GRADING & DRAINAGE PLAN
LOT 1, BLOCK A,
BELTWOOD NORTH PHASE I
AN ADDITION TO THE CITY OF ADDISON,
DALLAS COUNTY, TEXAS

Midway/Kellway (MKT) Phase I
Beltwood North Ph. I 5/97

GRADING & DRAINAGE PLAN
LOT 1, BLOCK A,
BELTWOOD NORTH PHASE I
AN ADDITION TO THE CITY OF ADDISON,
DALLAS COUNTY, TEXAS

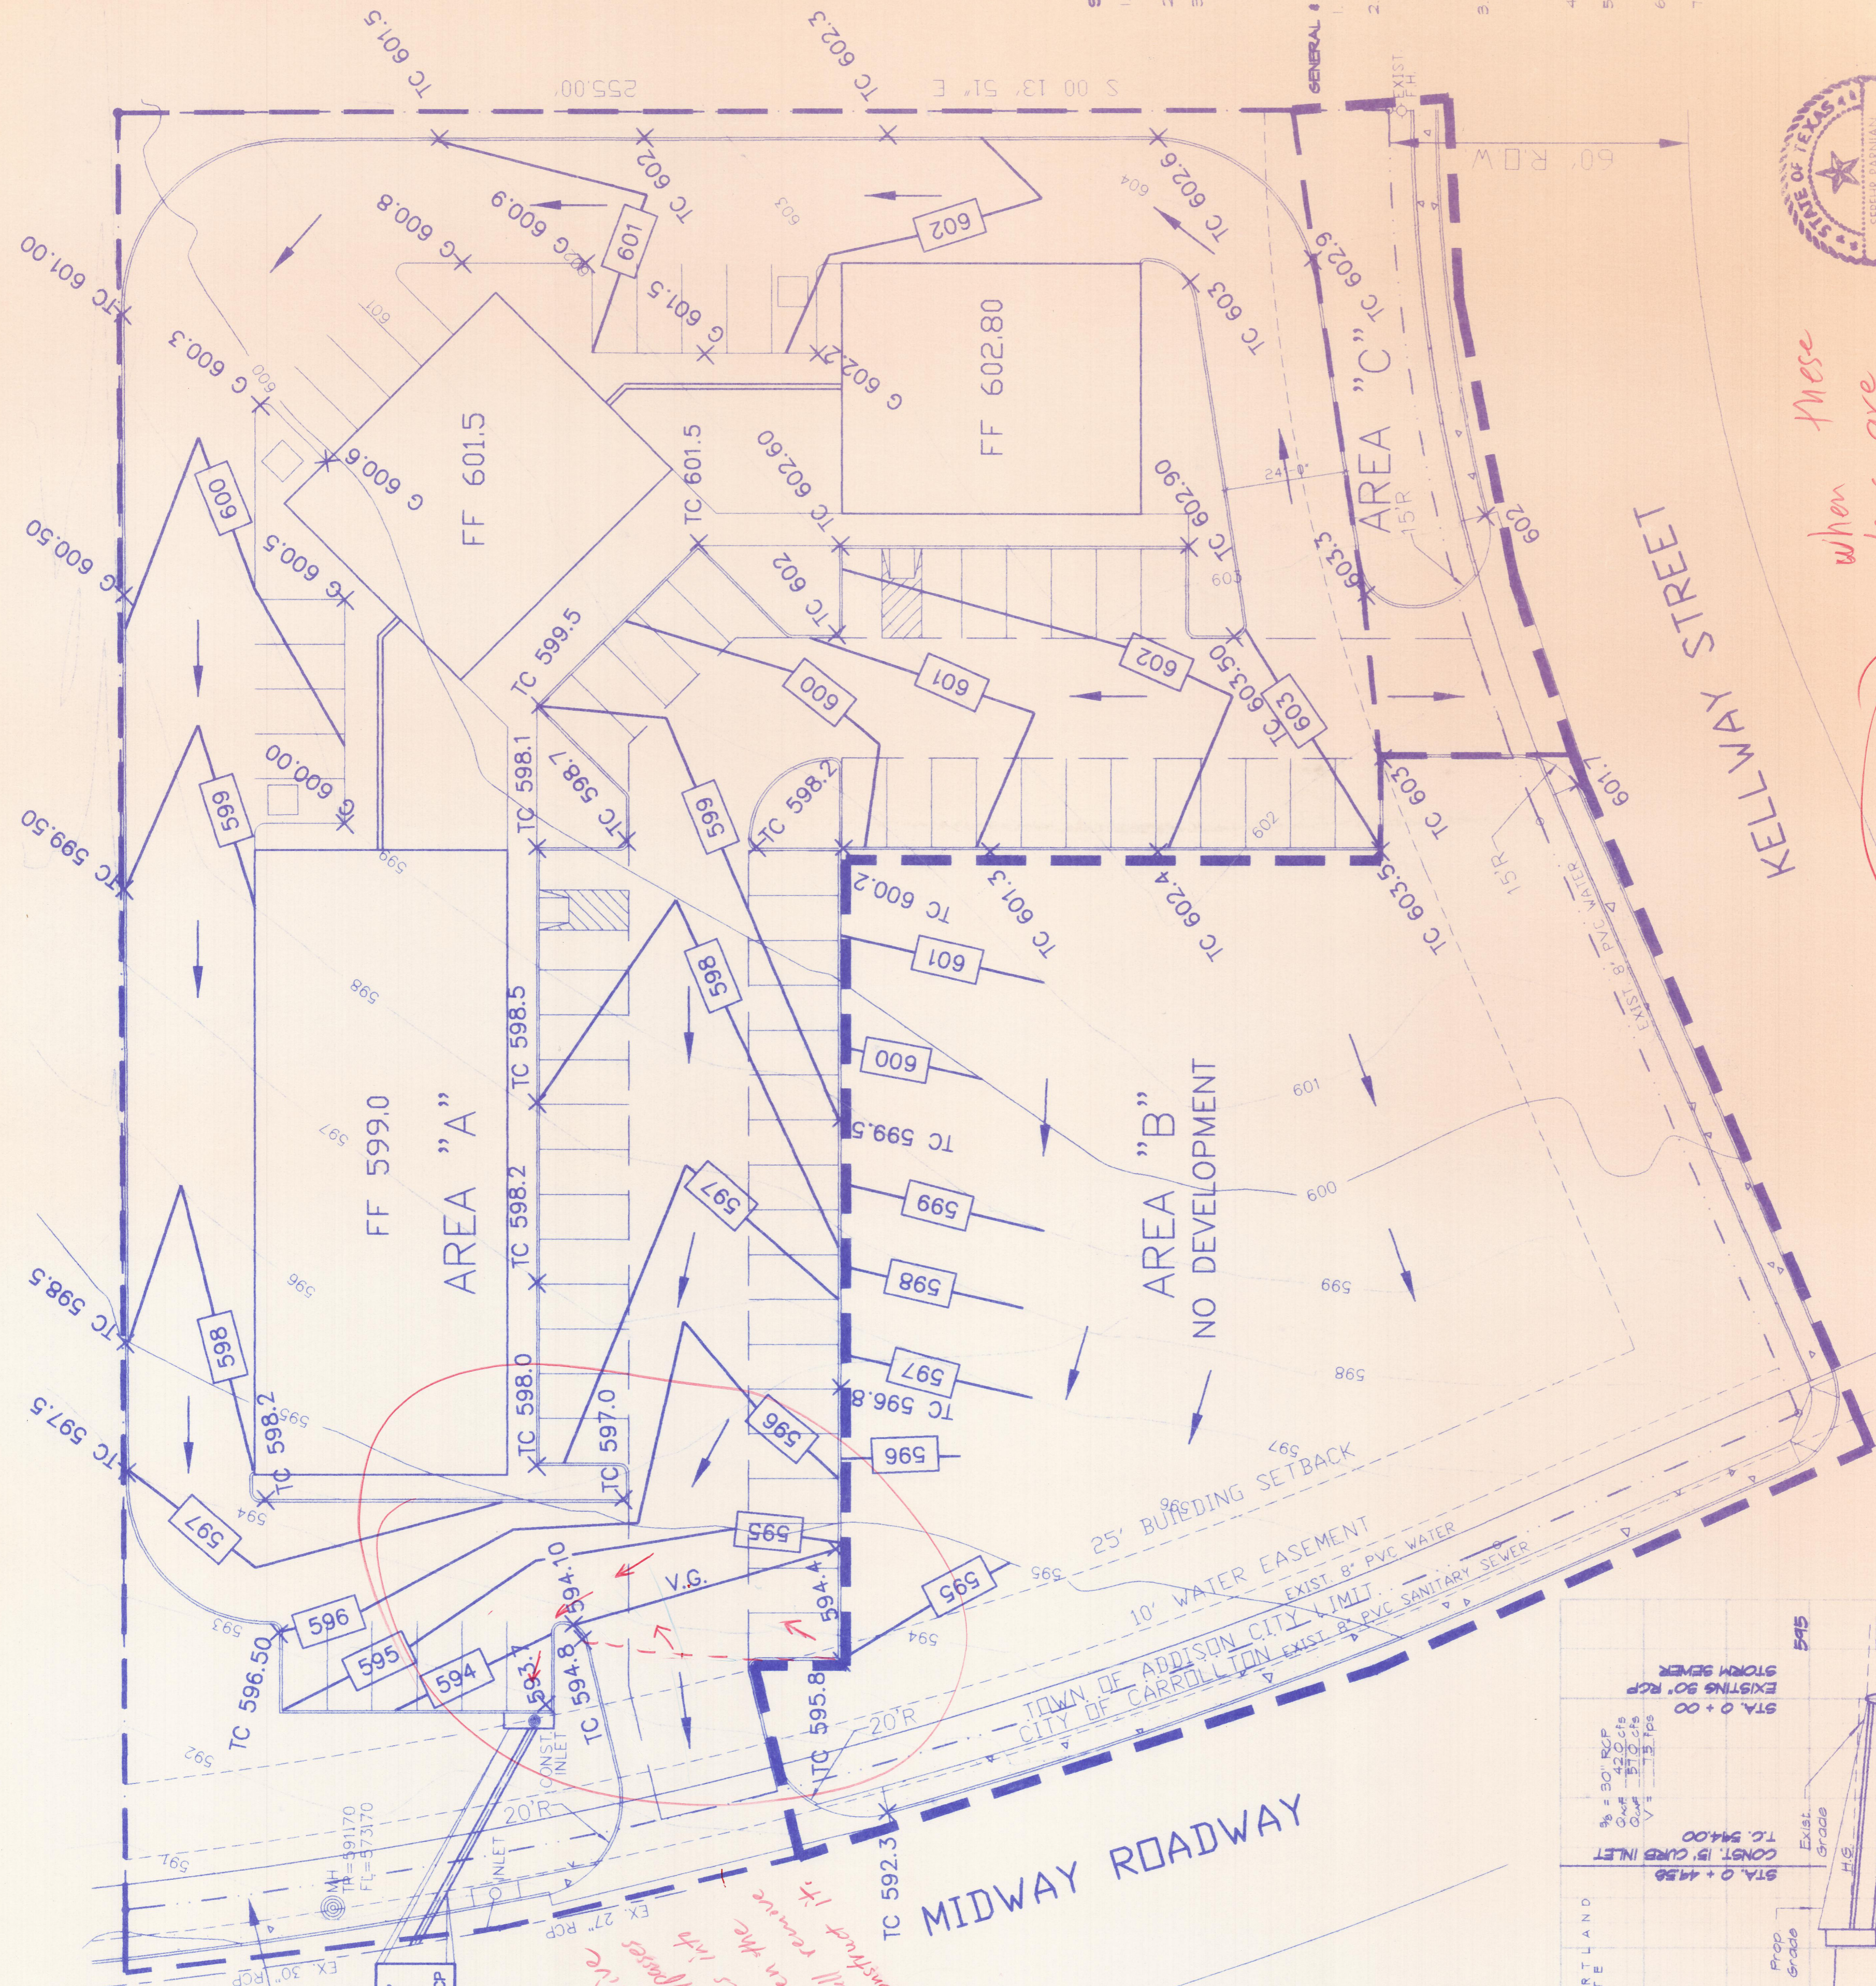
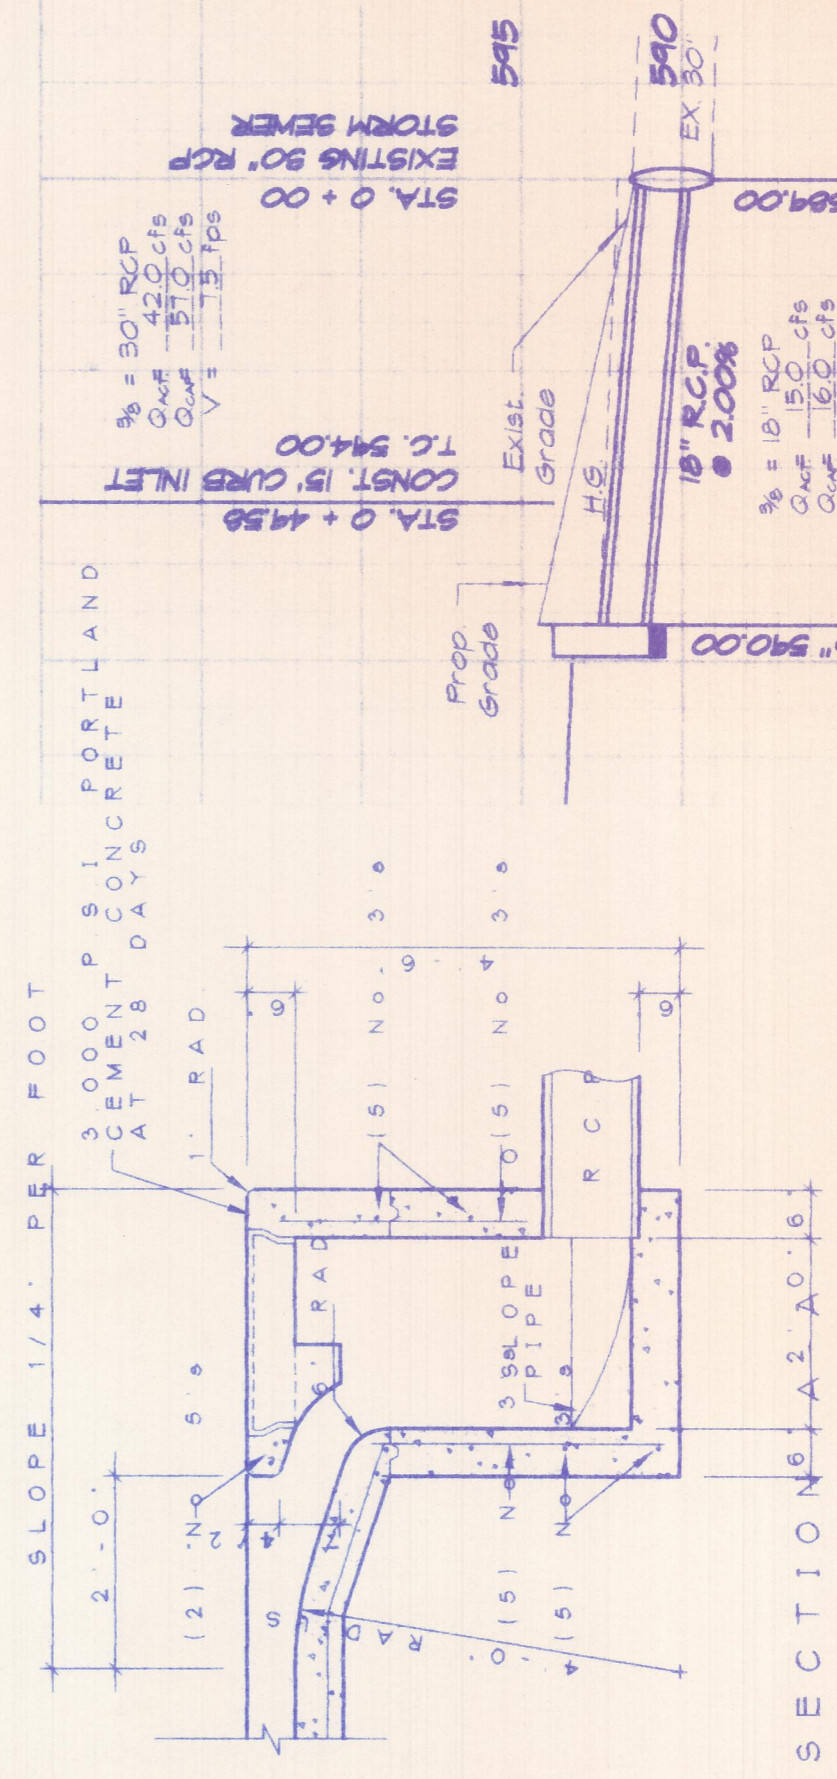
If the gutter the valley and gutter the inlet and gas into the street and reconstruct it. Contractor shall remove the inlet and gas into the valley effective

Return this marking revised plans

these plans are revised per the comments, the bldg. permit will be issued
